**CITY OF ALBUQUERQUE  
PLANNING DEPARTMENT  
February 27, 2013  
DRB Comments**

**PROJECT # 1009597**

**APPLICATION # 13-70453**

**RE: Lots 9-12, Block B, Juan Armijo Addition**

PLAT OF
LOTS 10-A, 11-A AND 12-A
BLOCK B
JUAN ARMIJO ADDITION

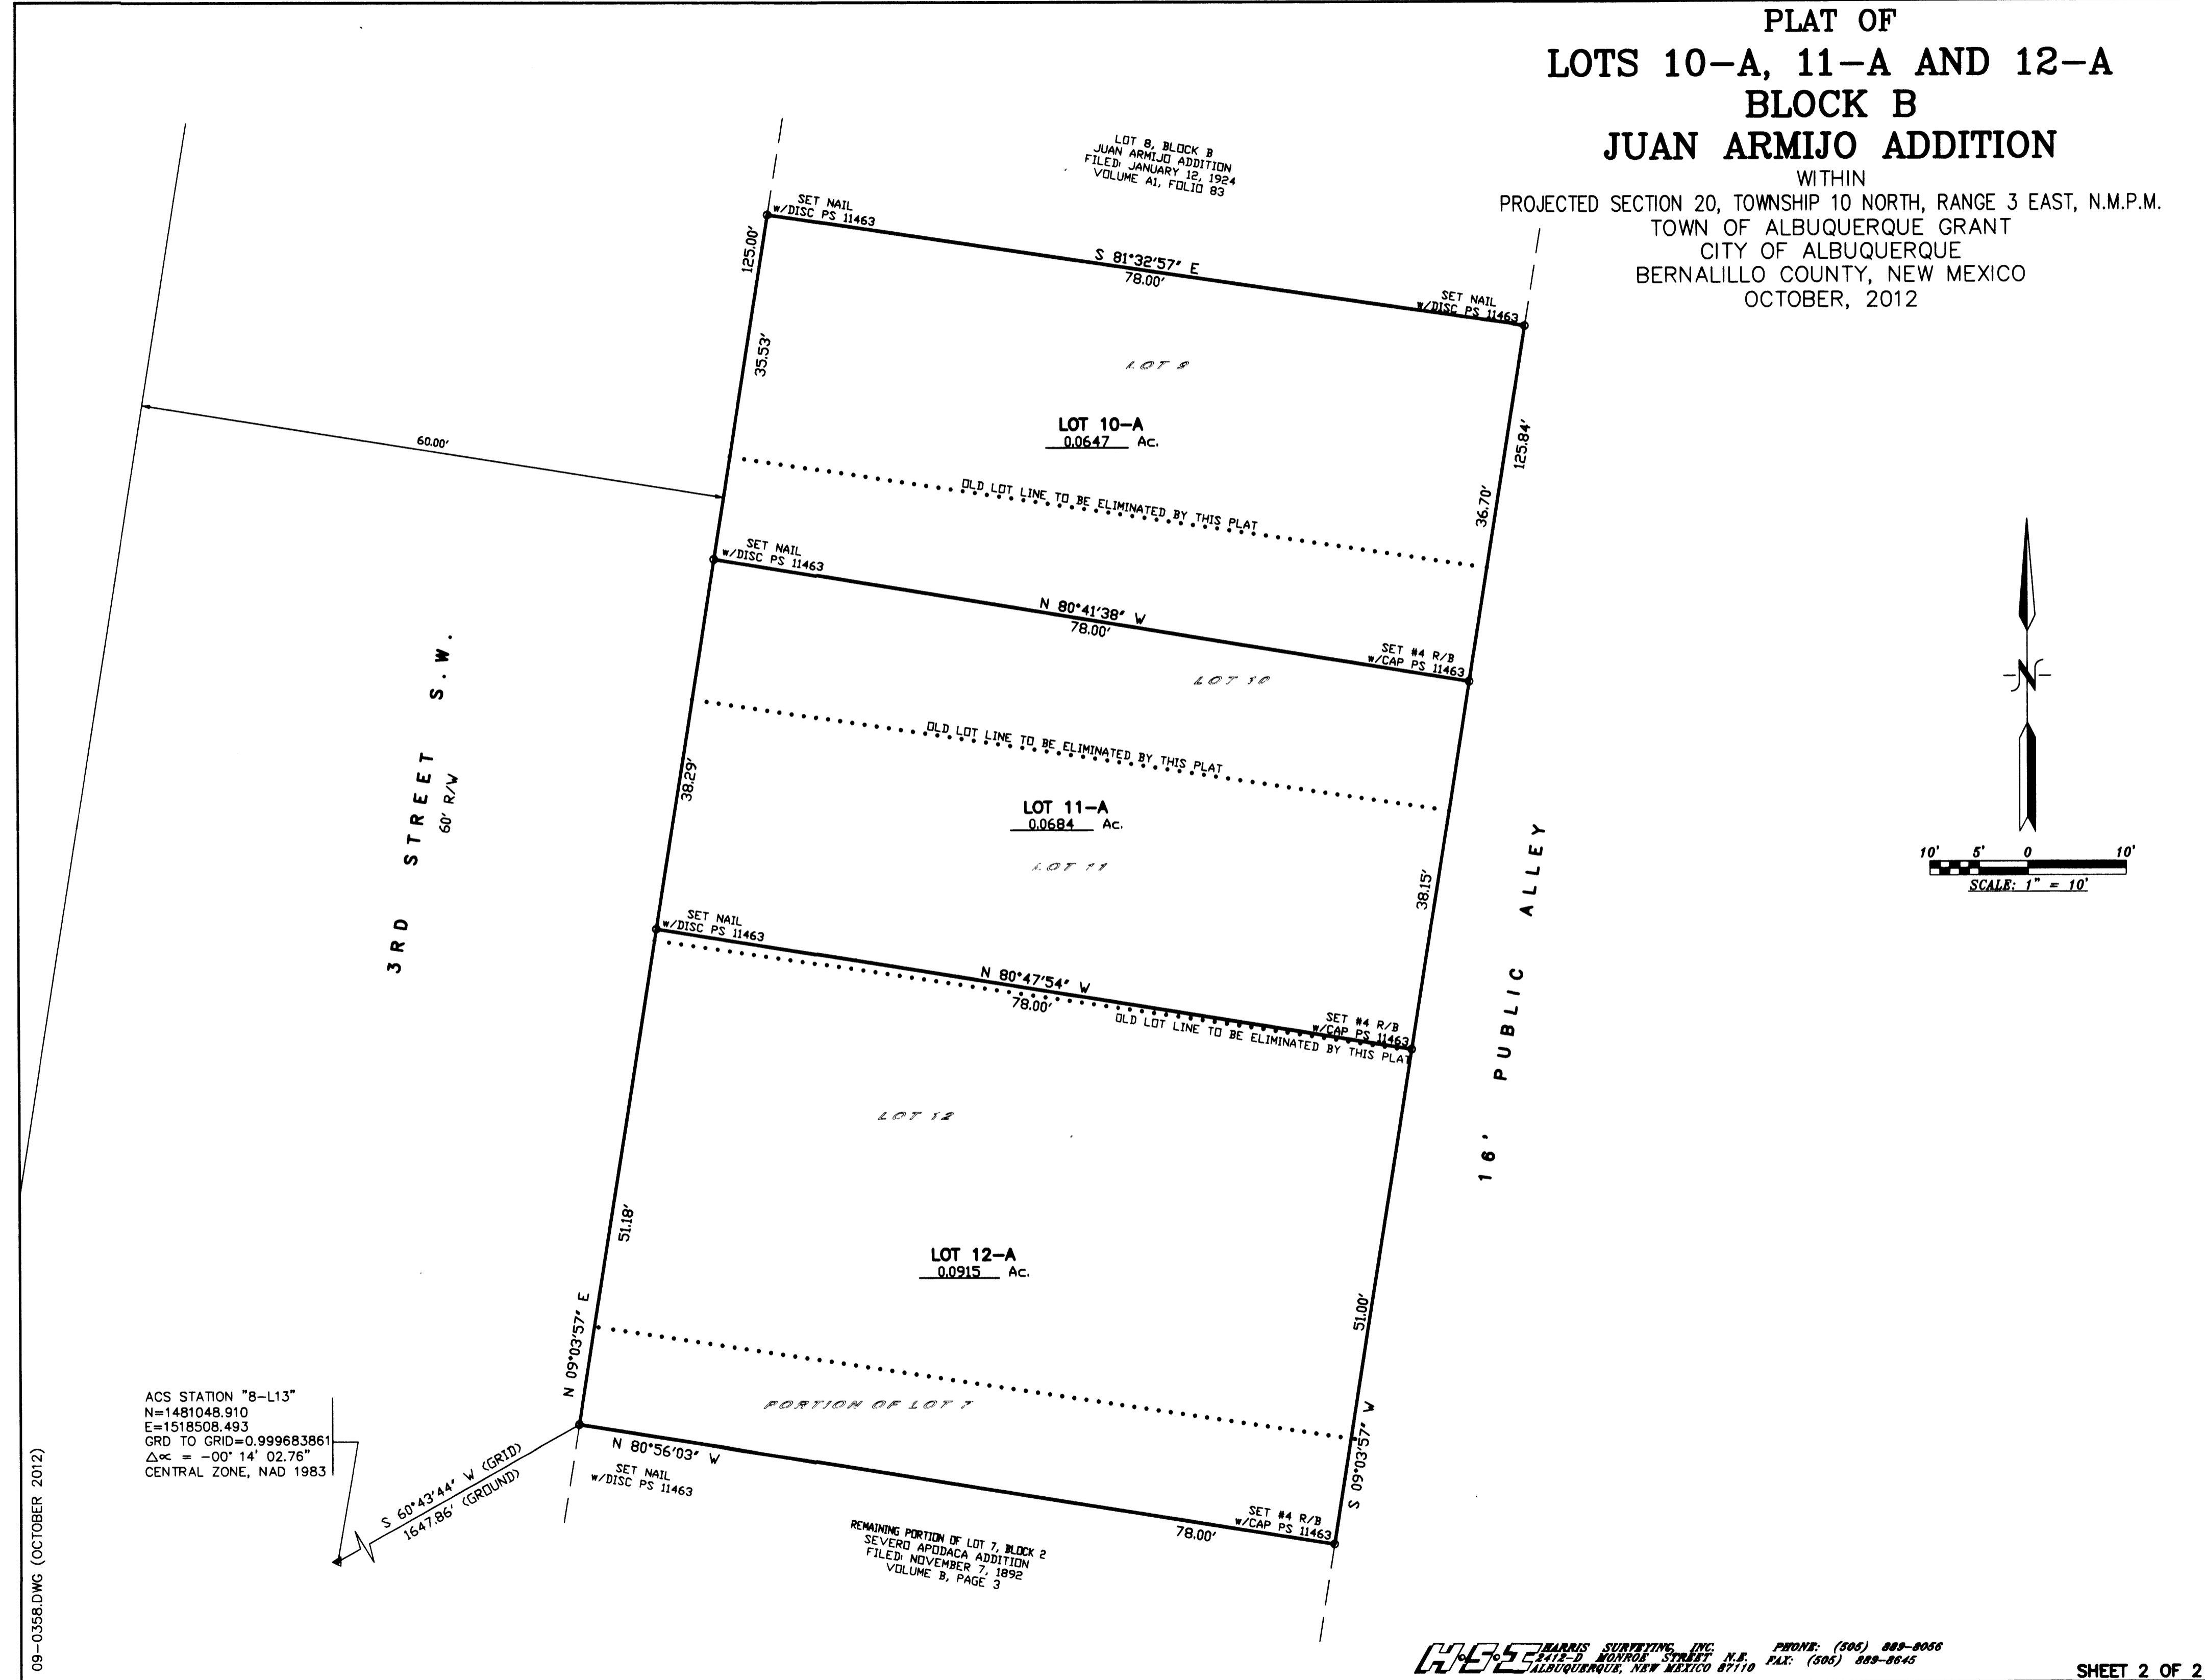
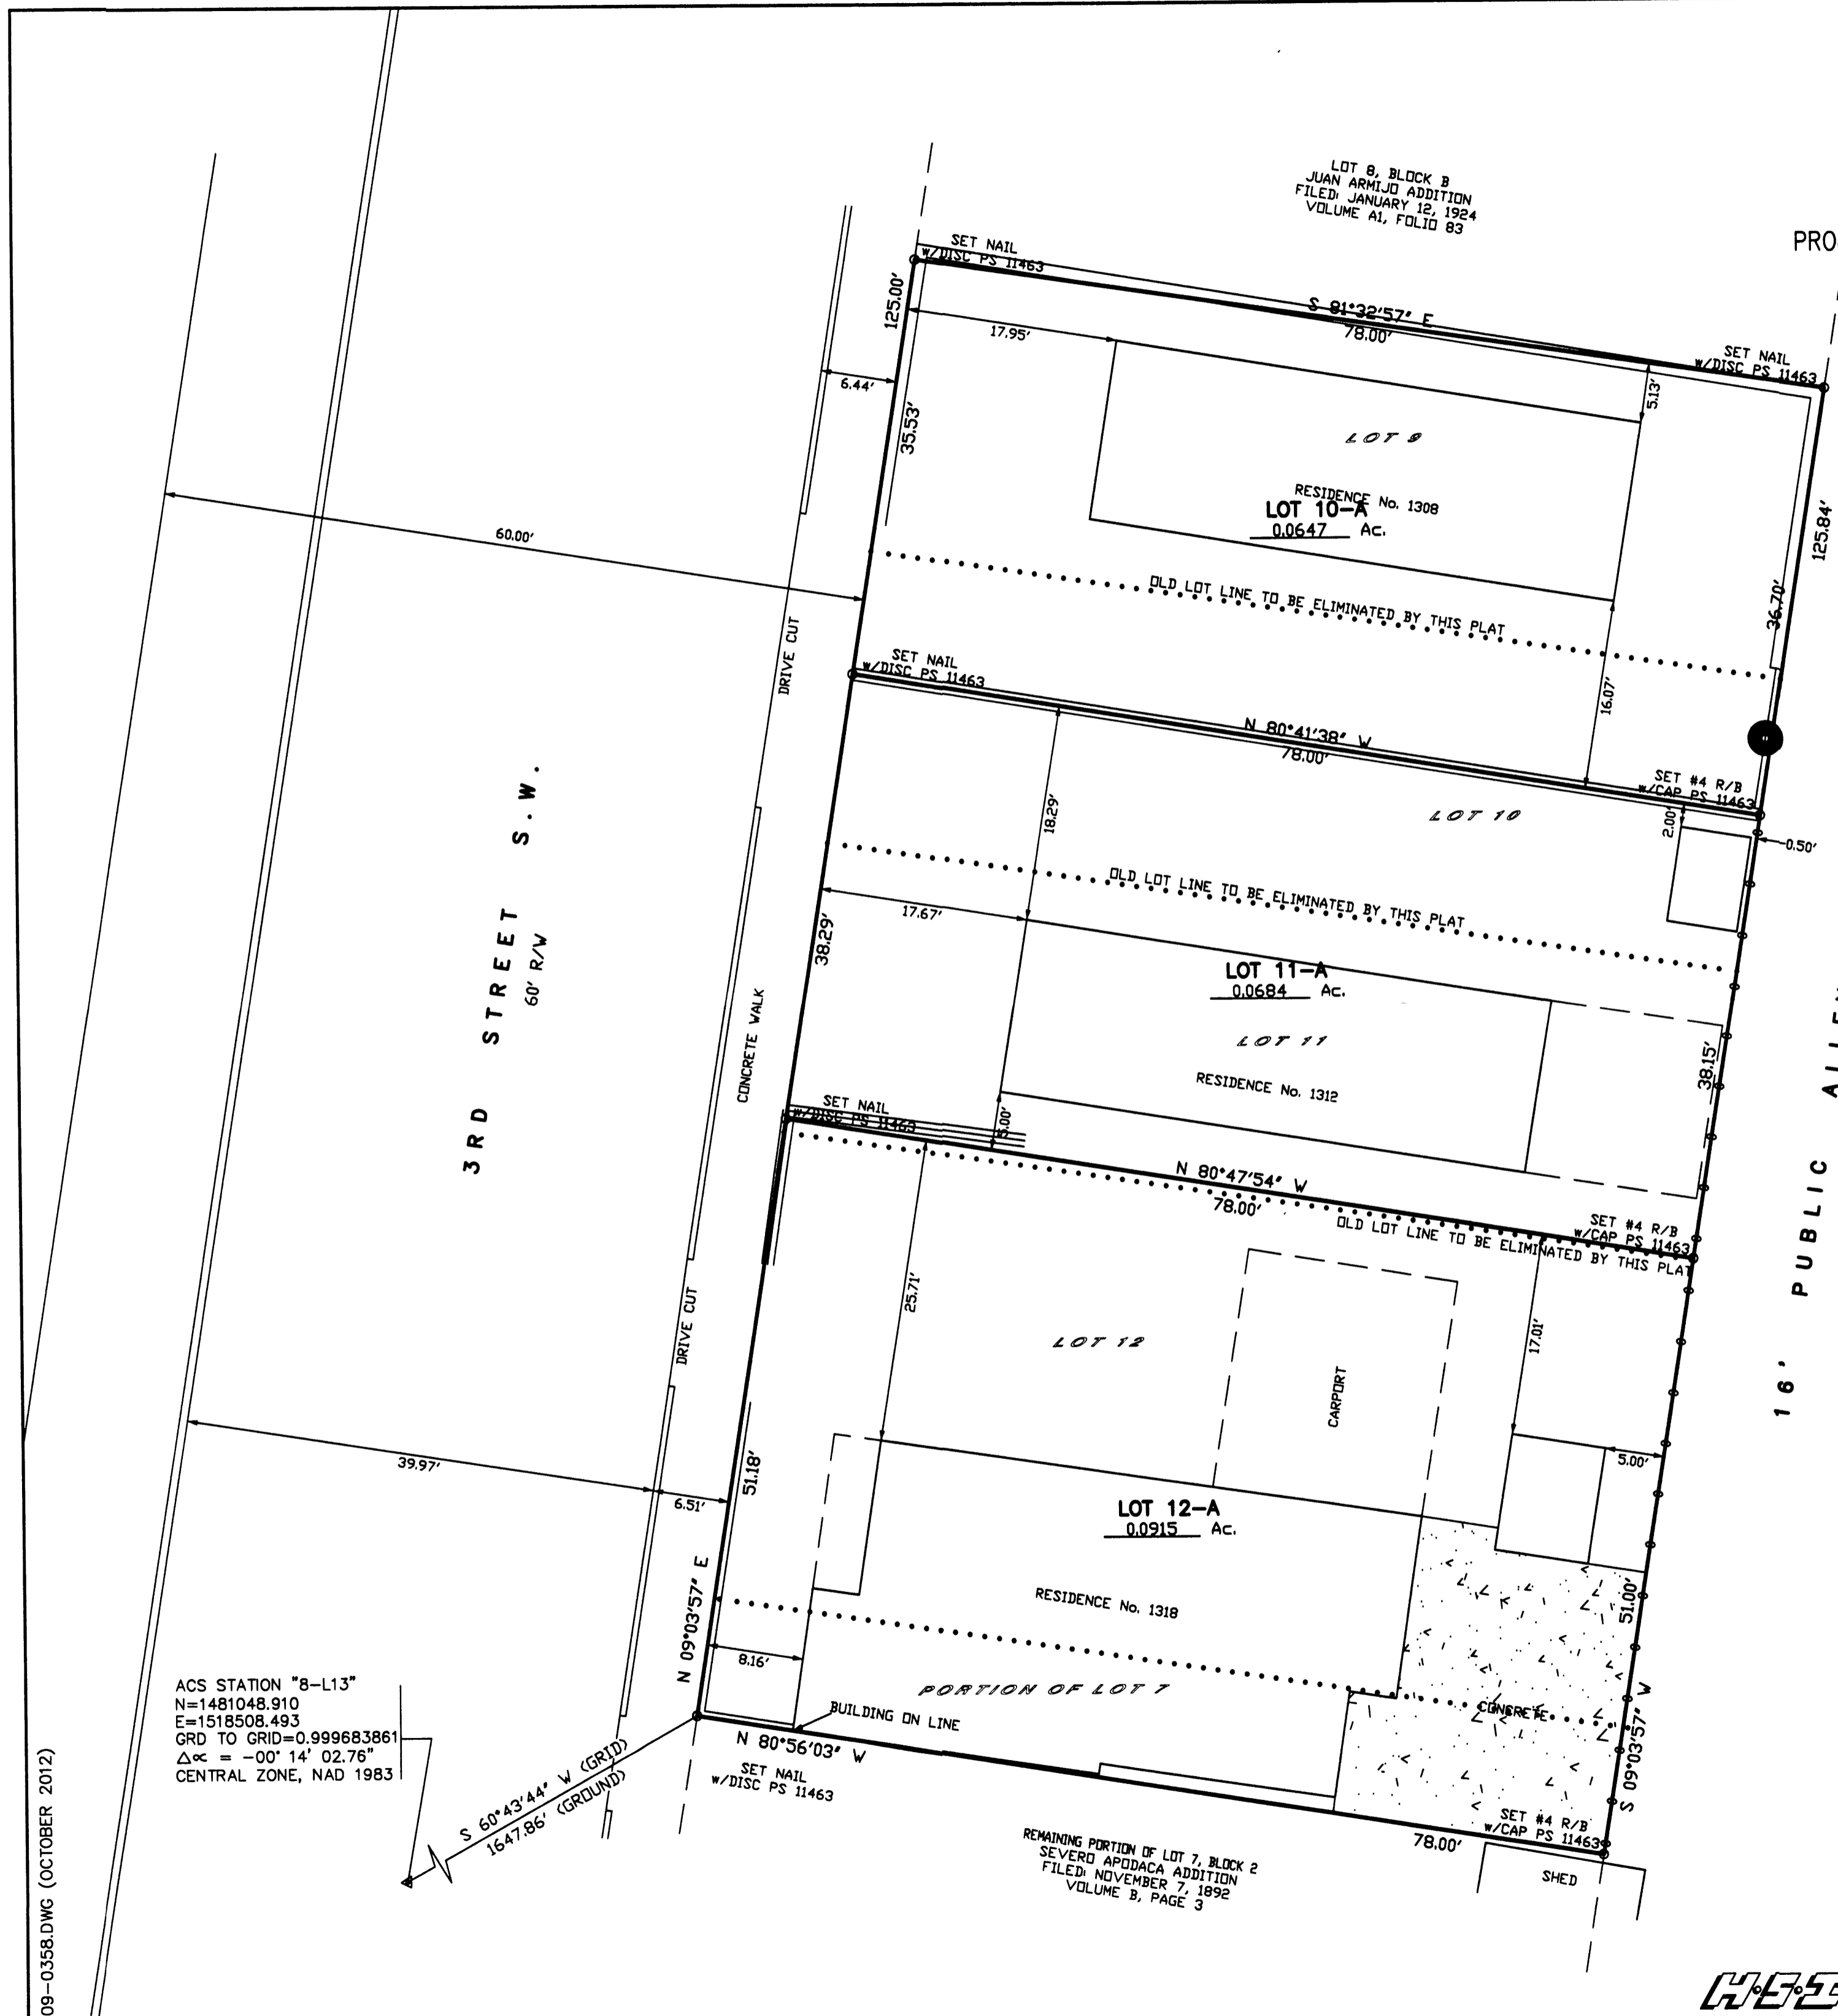
The drawing showing existing improvements appears different than the aerial photo, particularly at the rear of proposed Lot 11-A (there may be an encroachment into the alley).
